**Consultation Response from KC,
Lead Local Flood Authority**

2025/90889 Former Combs Hostel, Hall Lane, Thornhill, Dewsbury, WF12 0PL

Demolition of existing hostel and erection of residential development comprising 34 dwellings

Date Responded: 02/04/2026

Job No.	Drawing No.	Revision
21-105	D01	C
Scales	NTS	
Drawn by	Date	Checked
IAP	22.03.21	NM

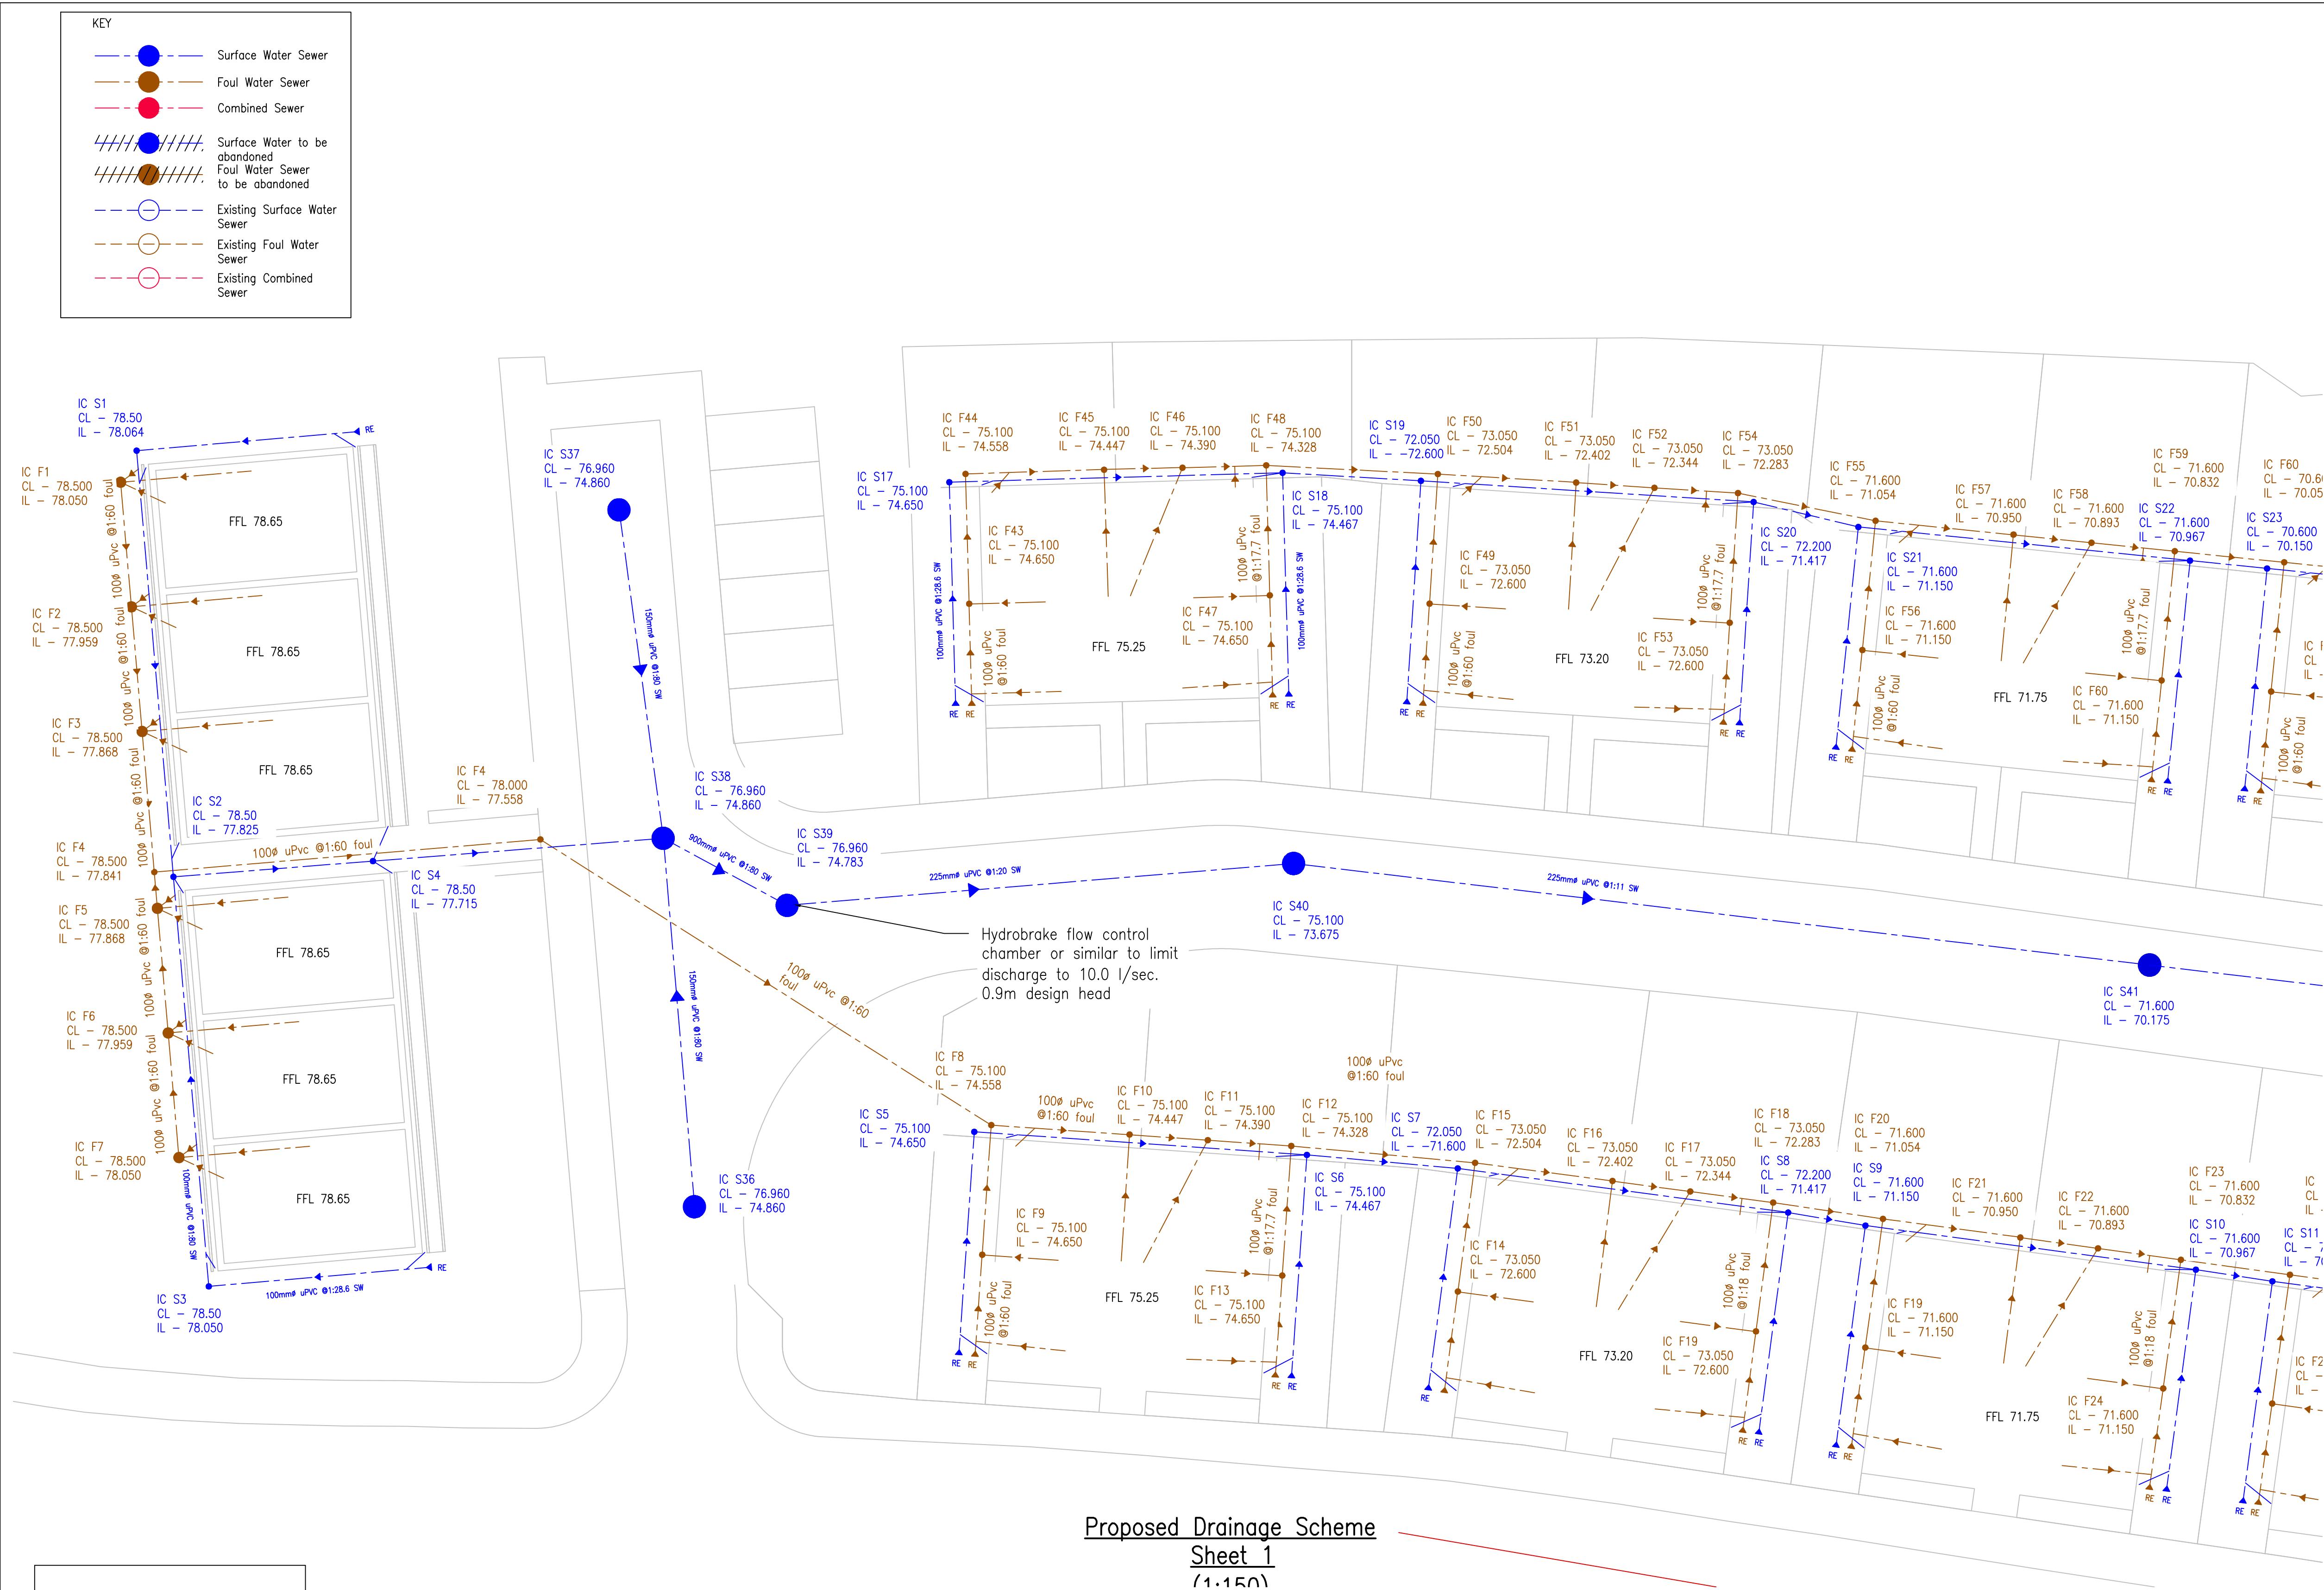
The Drainage Statement refers to an allowable surface water discharge of 16.5l/s whereas the Drainage Plan refers to 14.5l/s at the final discharge point and indicates a single attenuation tank whereas the Plan shows 2 tanks.

Appendix C of the Drainage Statement refers Yorkshire Water has suggested that the surface water run-off is discharged to a nearby watercourse – it is not understood by the LLFA that Yorkshire Water has accepted the proposal to discharge surface water to the combined sewer.
